25 March 2022

RE: LANG WALKER AO MEDICAL RESEARCH BUILDING LWMRB, MACARTHUR – SSD- 17491477 RESPONSE TO SUBMISSIONS

Blackash Bushfire Consulting

CANOPY COVERAGE

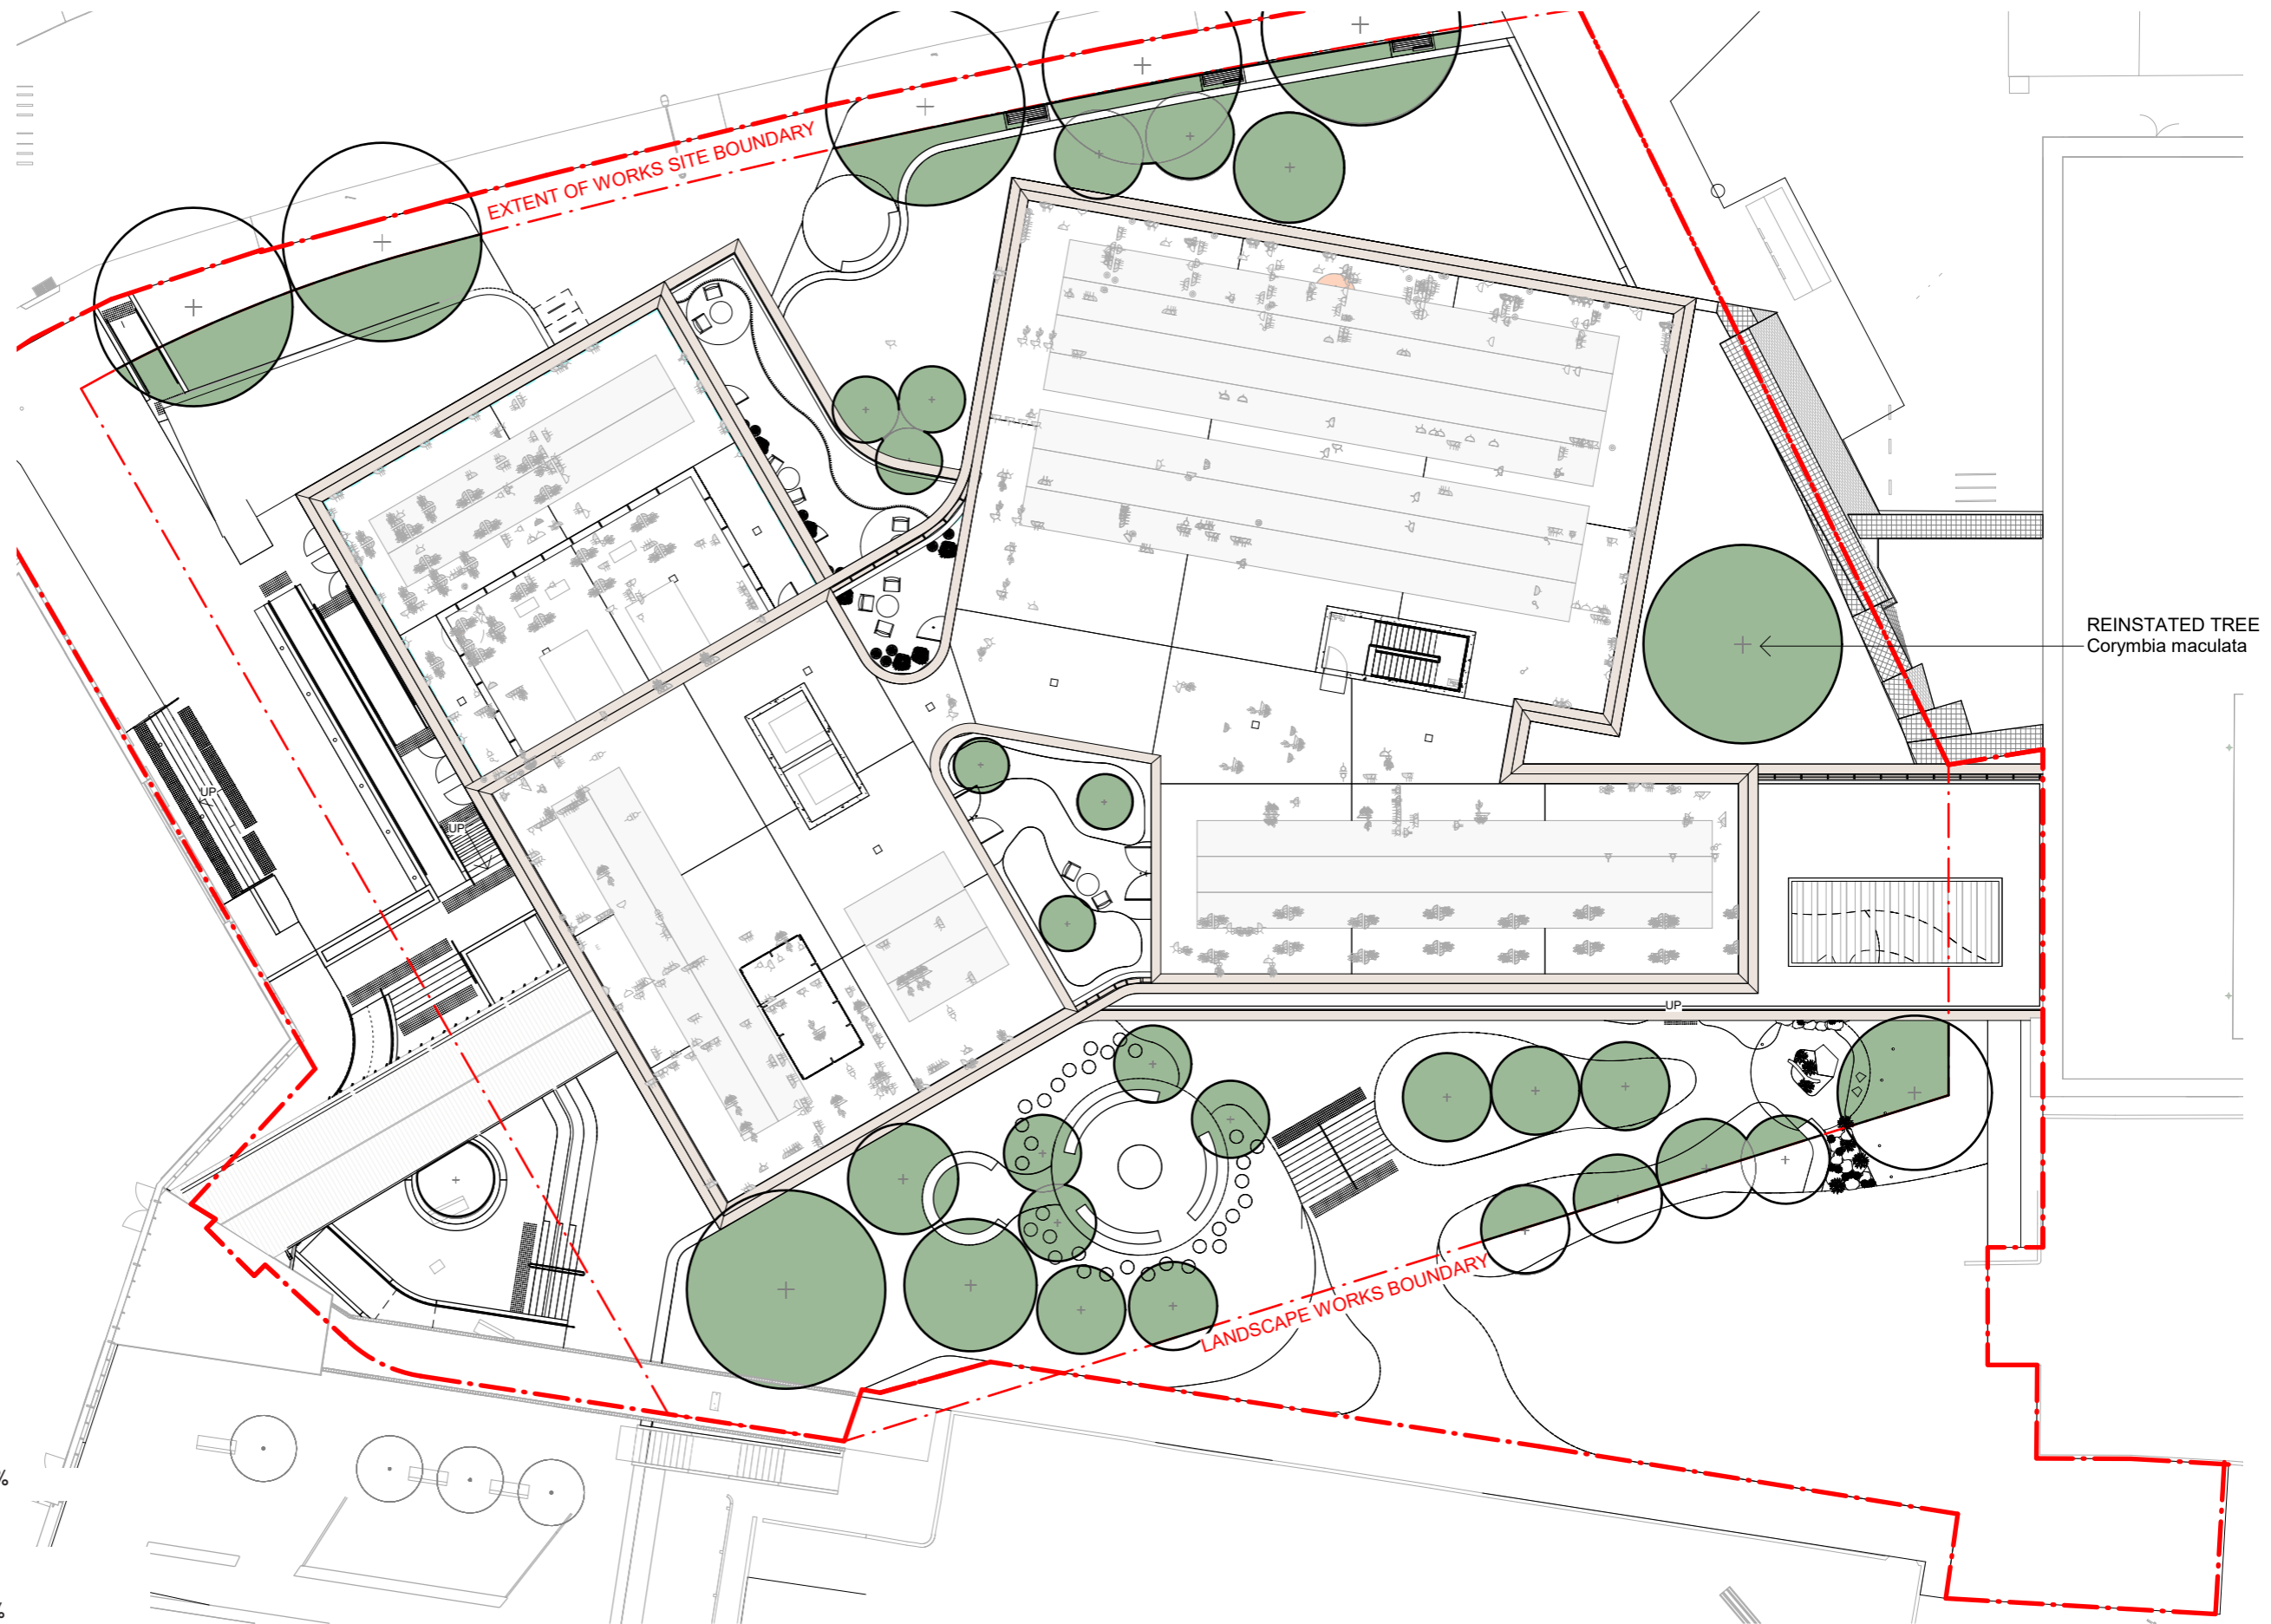
- 1. A minimum 1 metre wide area (or to the property boundary where the setbacks are less than 1 metre), suitable for pedestrian traffic, must be provided around the immediate curtilage of the building;*
- 2. Landscape species are chosen to ensure tree canopy cover is less than 15% (IPA), and less than 30% (OPA) at maturity and trees to not touch overhang buildings;*
- 3. Low flammability vegetation species are used.*

1. The site is greater than 67m from adjoining bushfire prone land and is a low bushfire risk. There are no requirements within RFS documents that stipulate a 1m wide area and therefore the 600mm provides access for pedestrians and fire fighters.
2. Trees and planting has been provided to meet IPA requirements. Ongoing management will ensure IPA is maintained to the life of the development.
